City of Portland, Maine - Building or Use Permit Application

Permit No: 01-0440	Issue Date: MAY 16 2001	CBL: 413 B011001
-----------------------	----------------------------	---------------------

Location of Construction: 41 Copley Woods Circle lot 11	Owner Name: Kto Builders Inc	Owner Address: 588 Roosevelt Ter. Windham	Phone: 207-892-2021
Business Name: n/a	Contractor Name: KTO Builders	Contractor Address: 588 Roosevelt Ter. Windham	Phone: 2078927812
Lessee/Buyer's Name: n/a	Phone: n/a	Permit Type: Single Family	Zone: R-3 PRUD

**FIRST & SECOND FLOOR PLAN**  
**LOT #11**  
**CAMPBELL RESIDENCE**

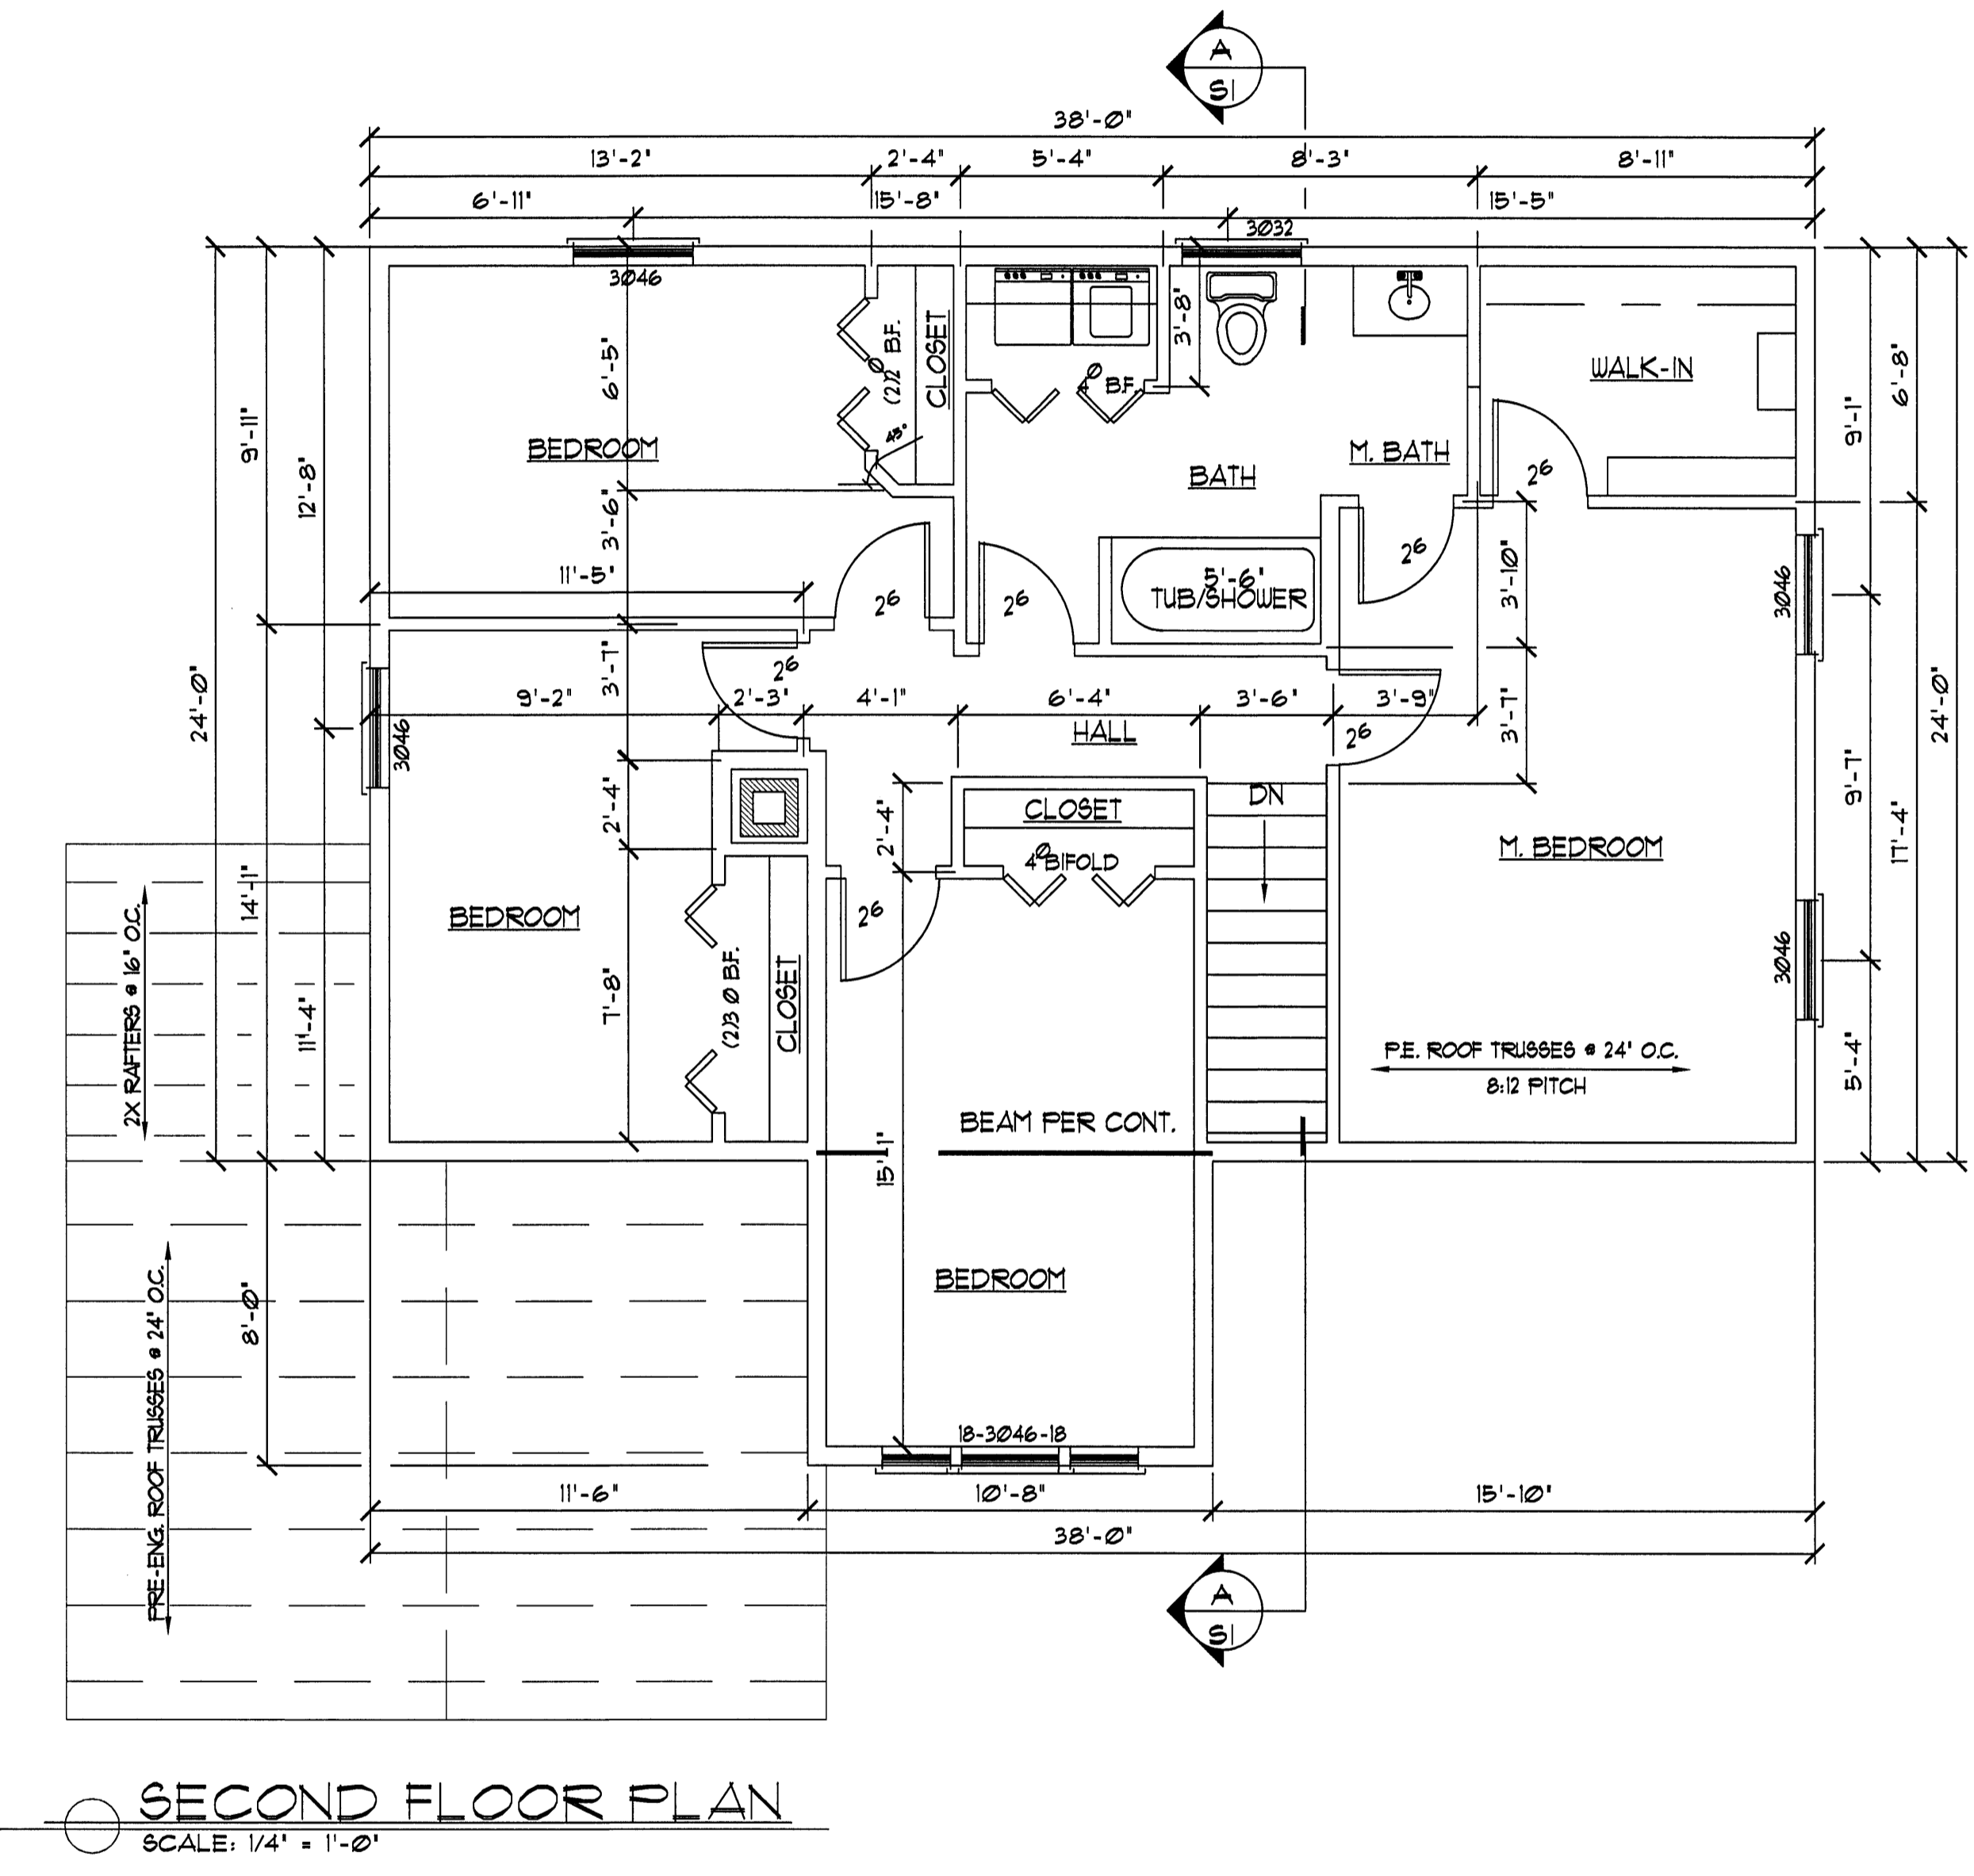
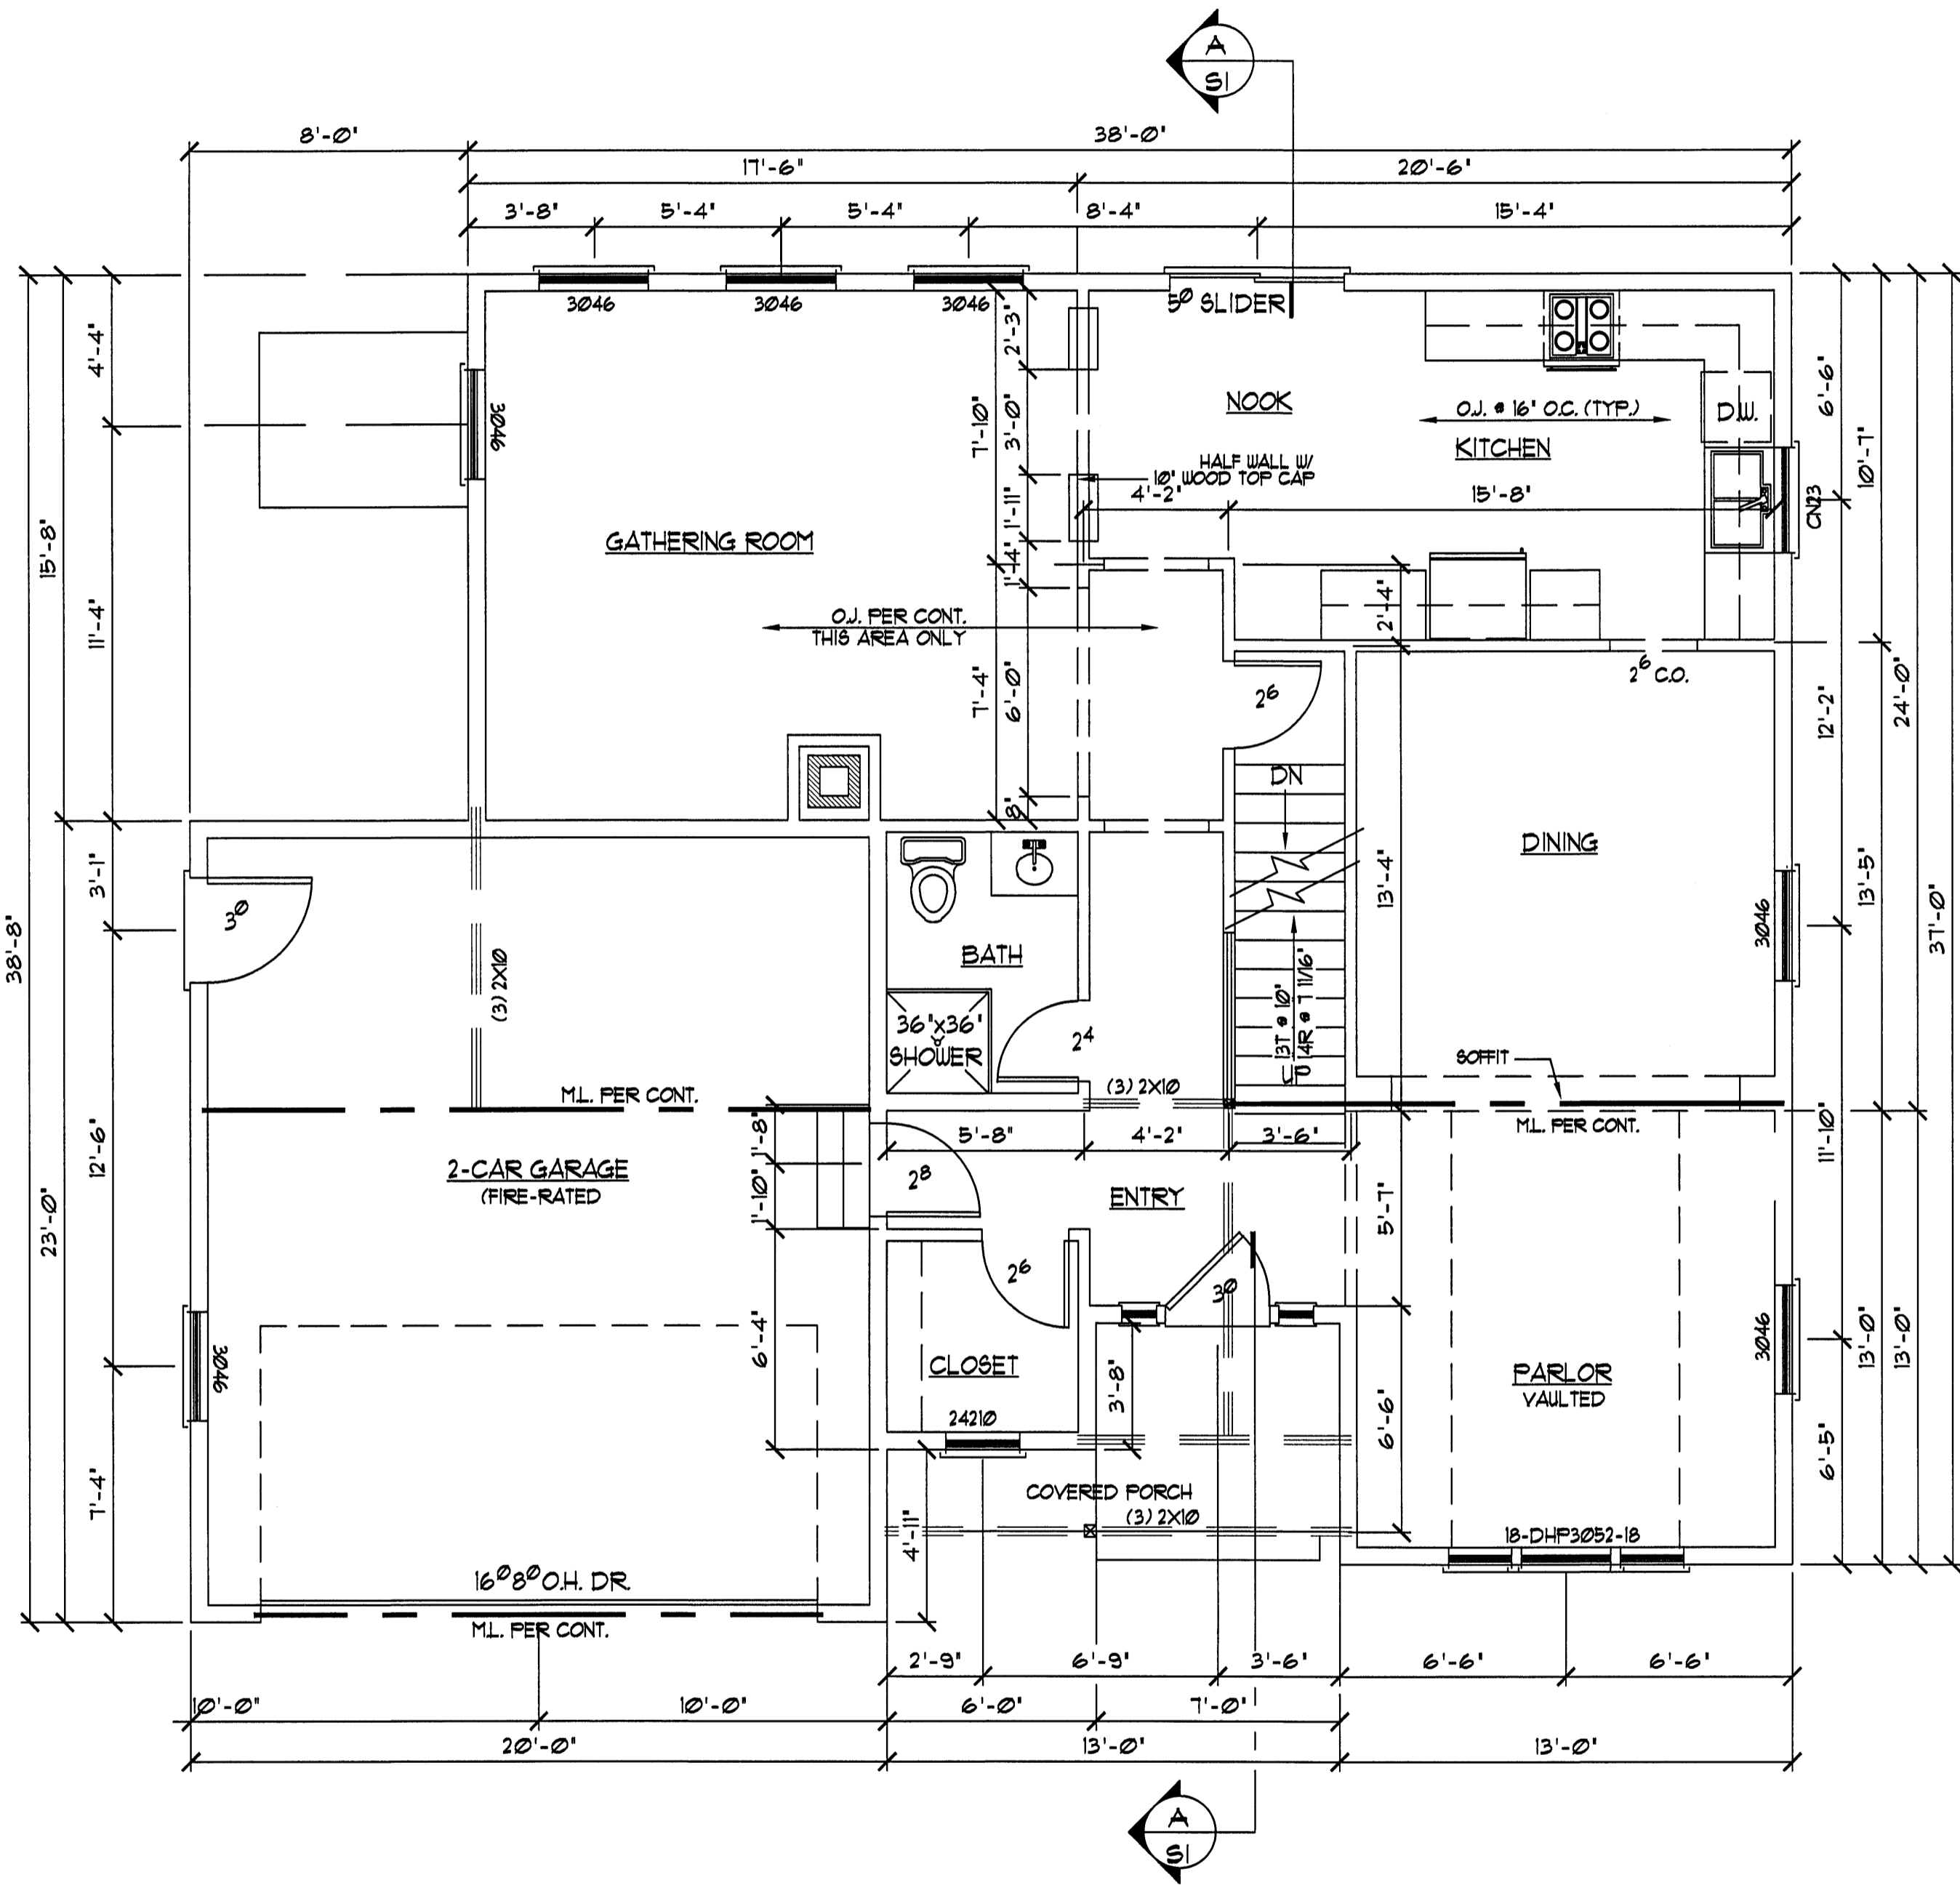
6-5-01: 2nd fl. Egress window 23 1/2" H x 16" W, Broken
steel @ Entry Closet, elect Boxes W/I 2' @
Garage Wall. No W/AR

6-20-01: Egress window measure 24 1/4" x 33 1/2"
elect Boxes Moved off Garage Wall

**FOUNDATION PLAN**  
**LOT #11**  
**CAMPBELL RESIDENCE**

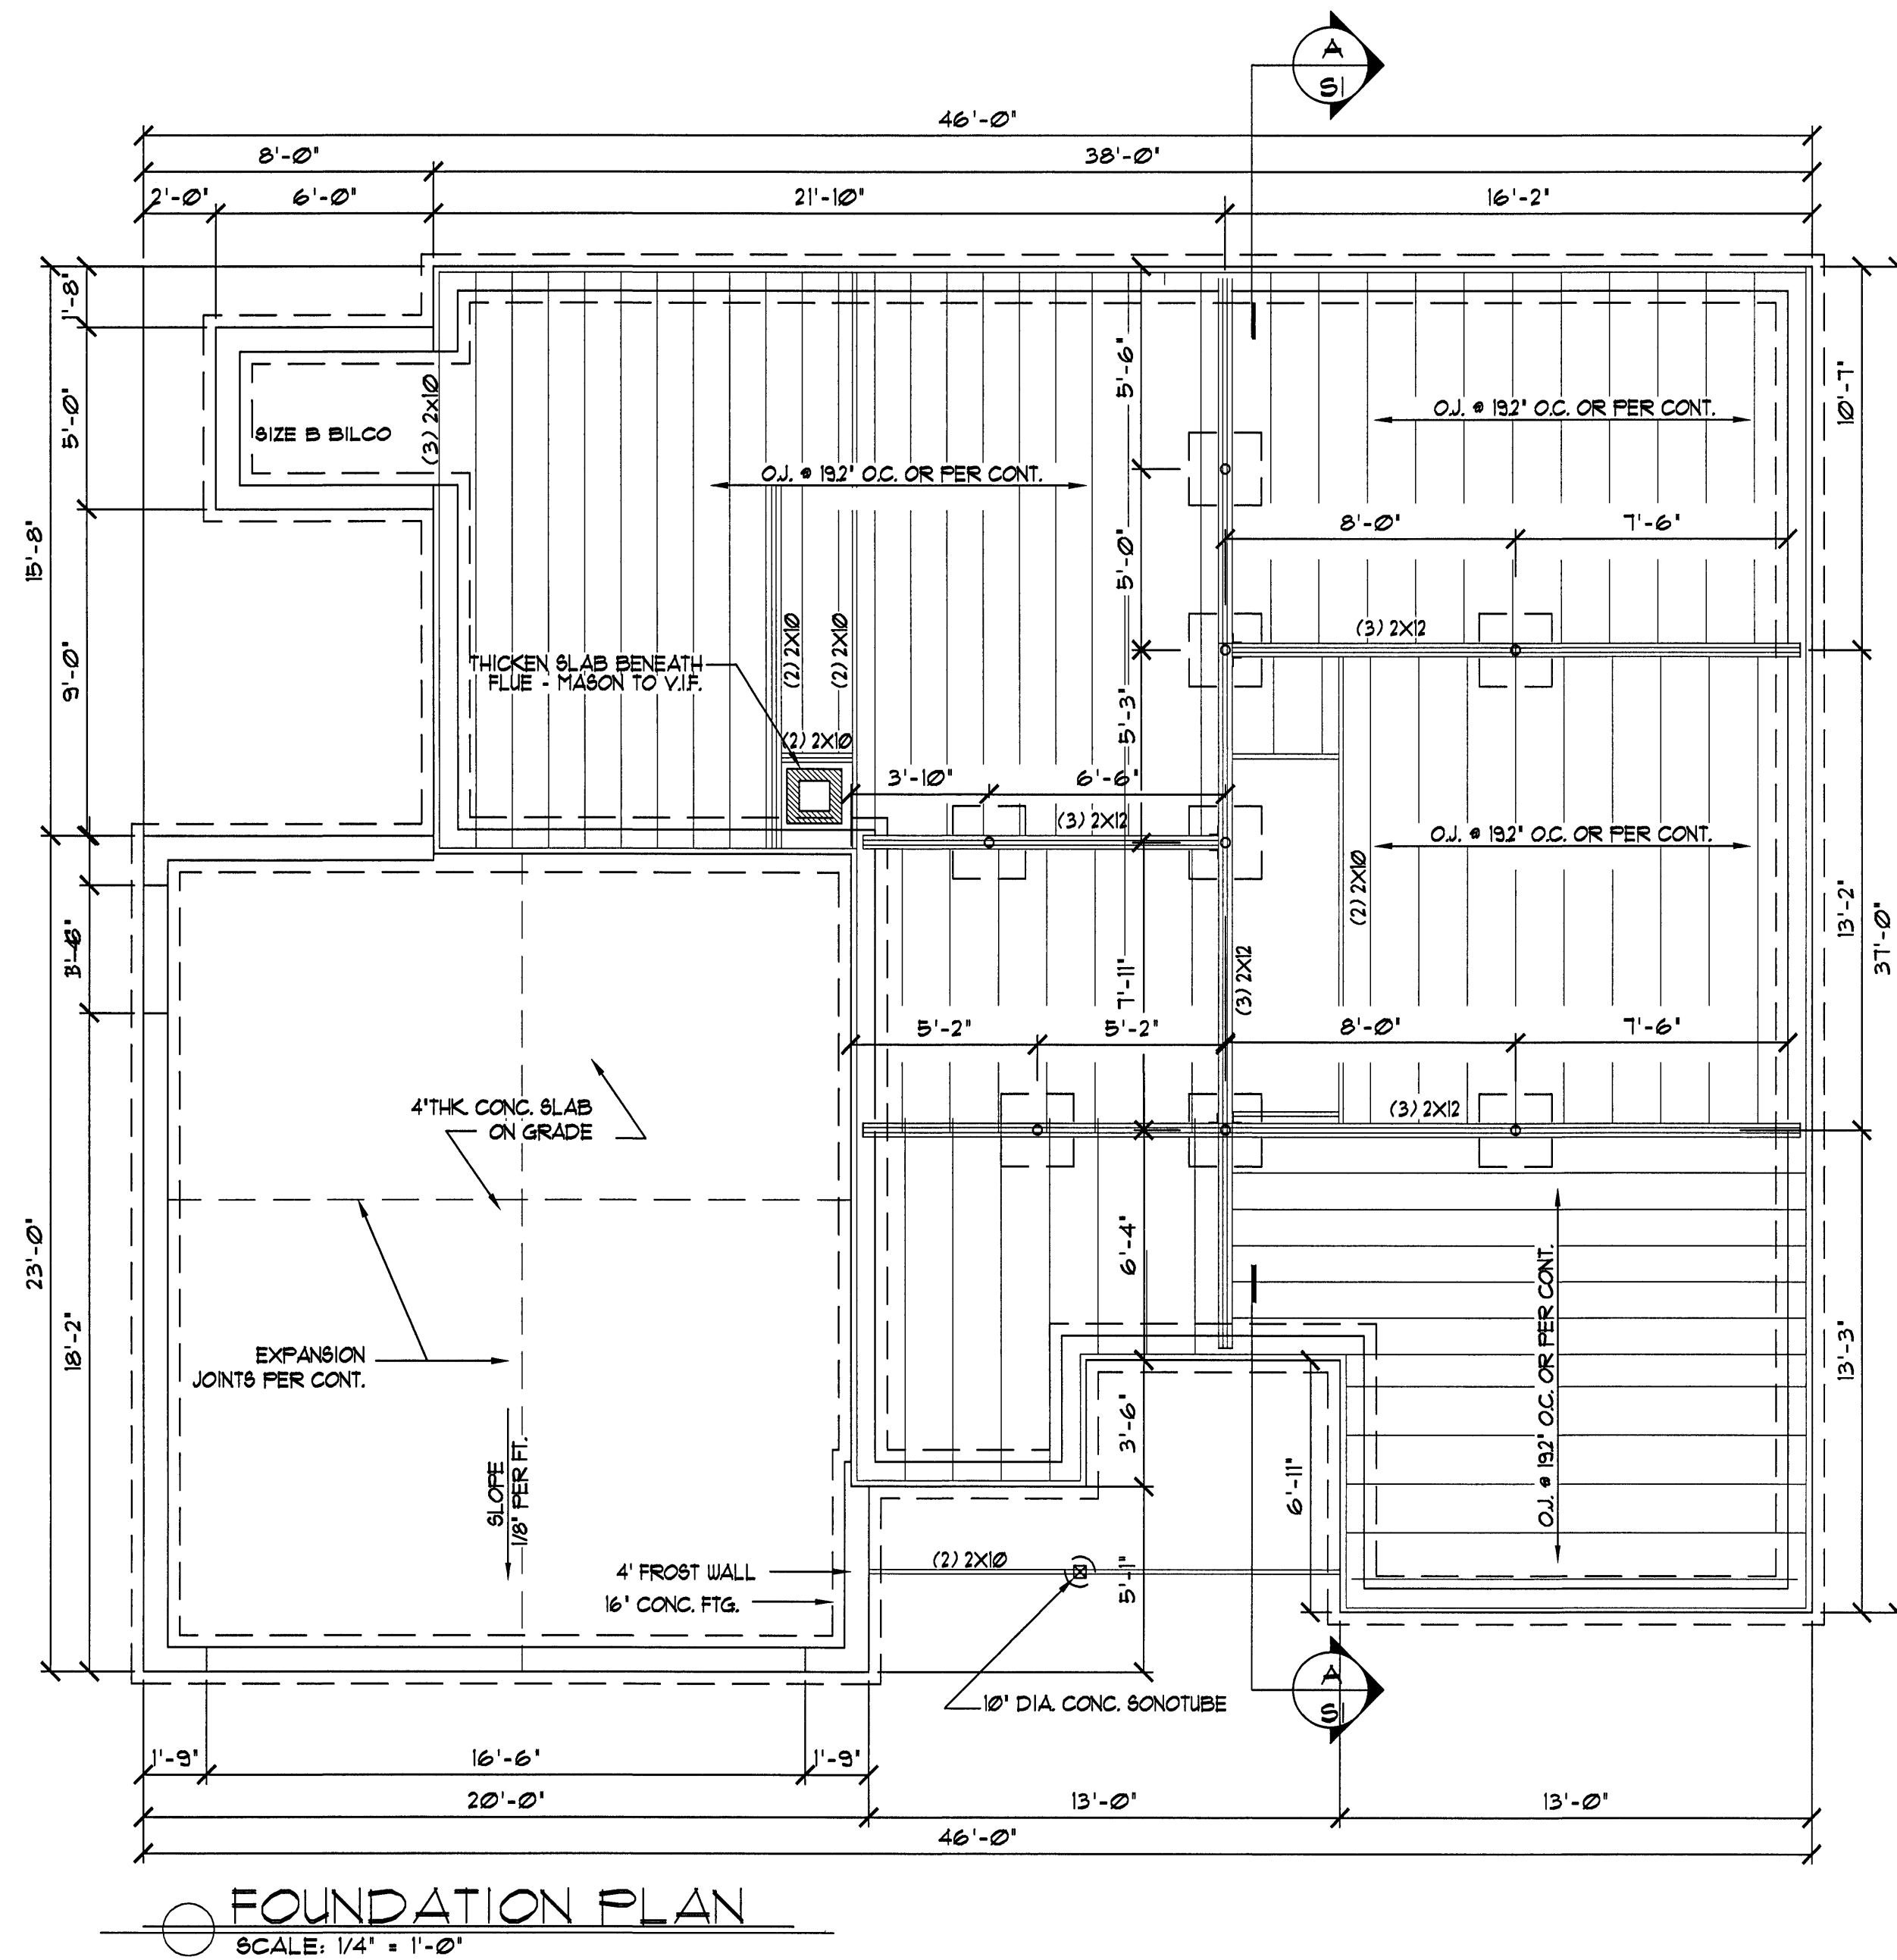
Lally 9'9" 3-2x12
Needs Lally support

15'3" 3-2x12 NO Lally support
need lally at 7'10" Beam
